REFUSAL OF PLANNING PERMISSION

APPLICATION NO. 2019/0767

Proposal Extension of garage to enable conversion into residential annex associated with No.7 Hall Close

At 7 Hall Close, Worsbrough Village, Barnsley, S70 5LN

PROPOSED GROUND FLOOR PLAN
SCALE 1:100 AT A3

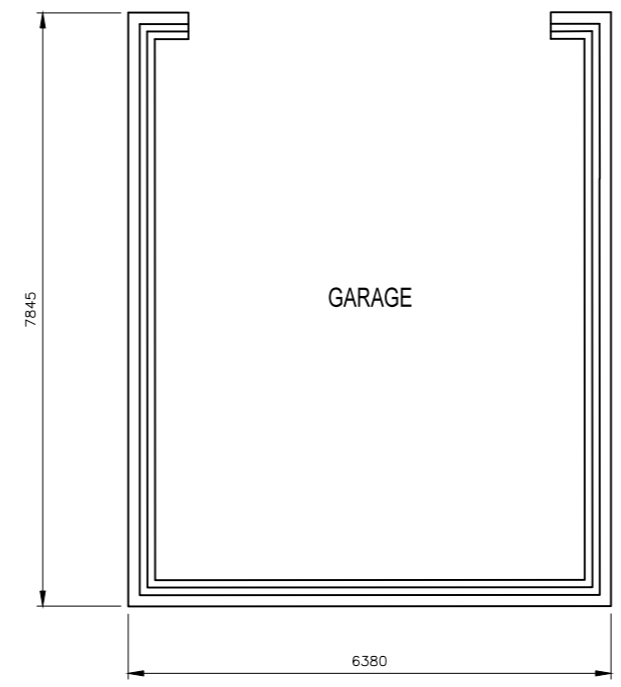
- 1 In the opinion of the Local Planning Authority, the detached outbuilding does not constitute an annex that would be ancillary accommodation to the host dwelling due to its substantial size as well as the number and type of rooms to facilitate independent living, which is contrary to Local Plan Policies GD1 & D1 and Supplementary Planning Document (SPD) - House Extensions and Other Domestic Alterations.

SITE PLAN
SCALE 1:500 AT A3

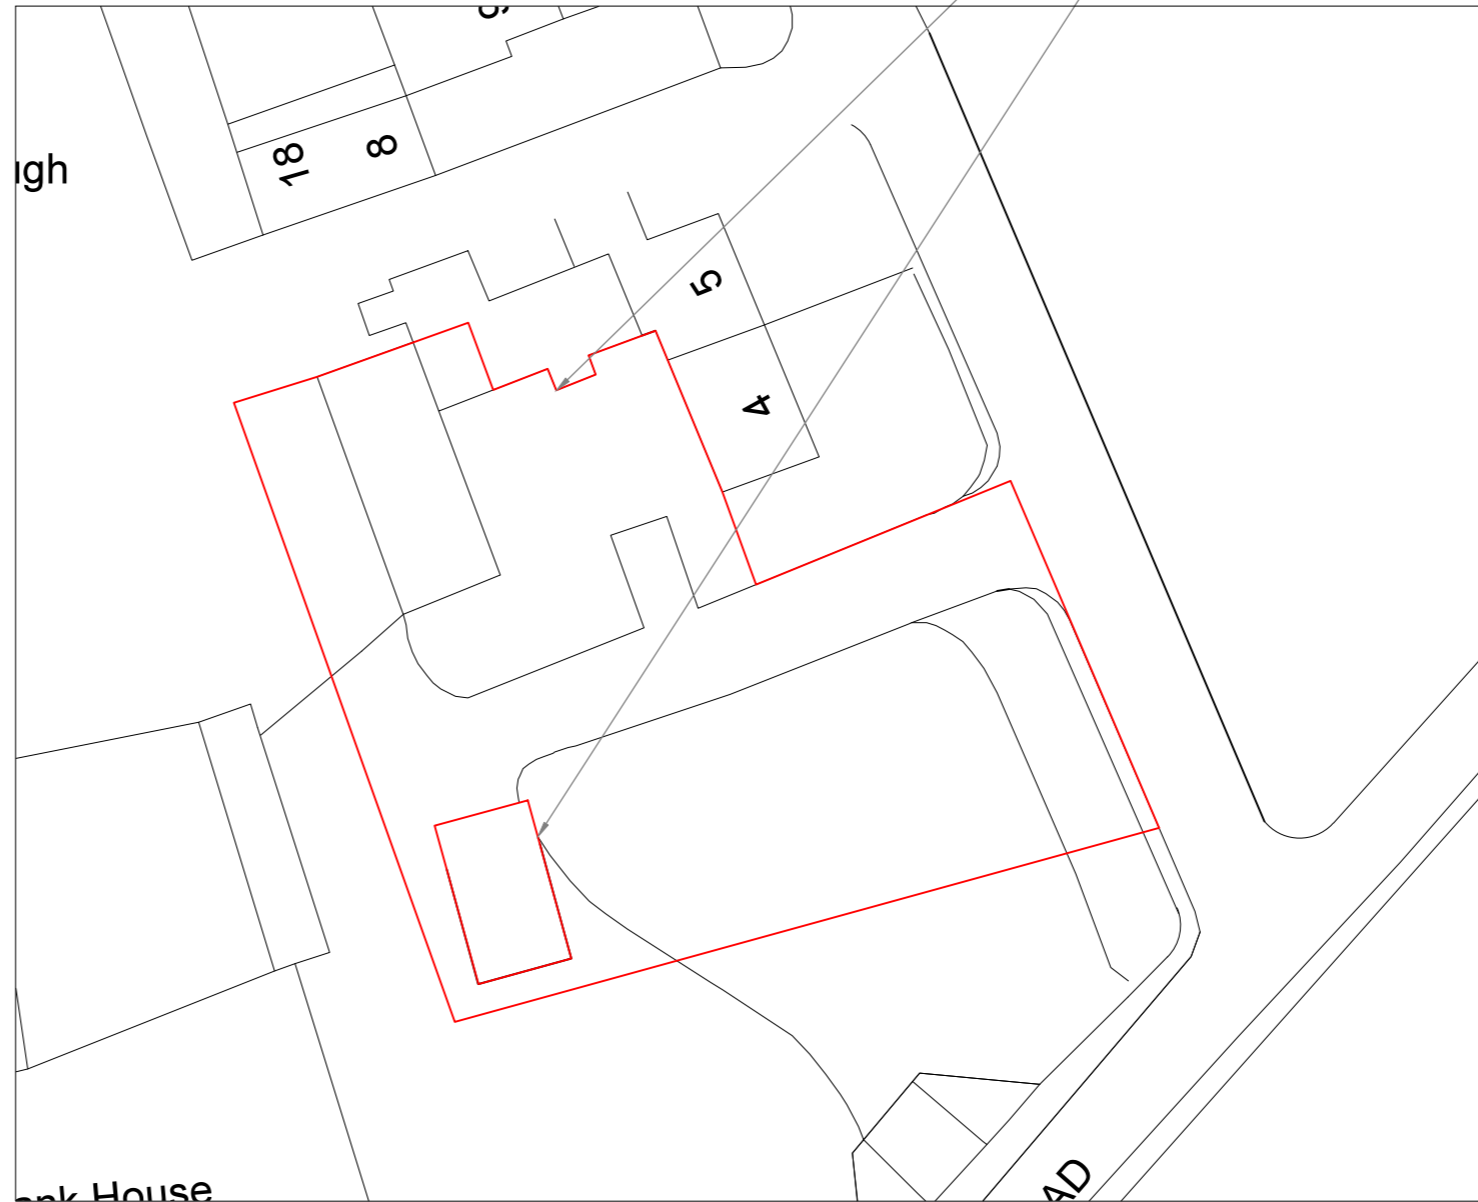
- 2 The proposed development, by reason of its scale, massing and siting forward of the front elevation of Worsbrough Hall would be detrimental to the special architectural and/or historic character of the Listed Building, contrary to Local Plan Policies HE1, HE2 & HE3 and Paragraphs 190, 190 & 195 of the National Planning Policy Framework.
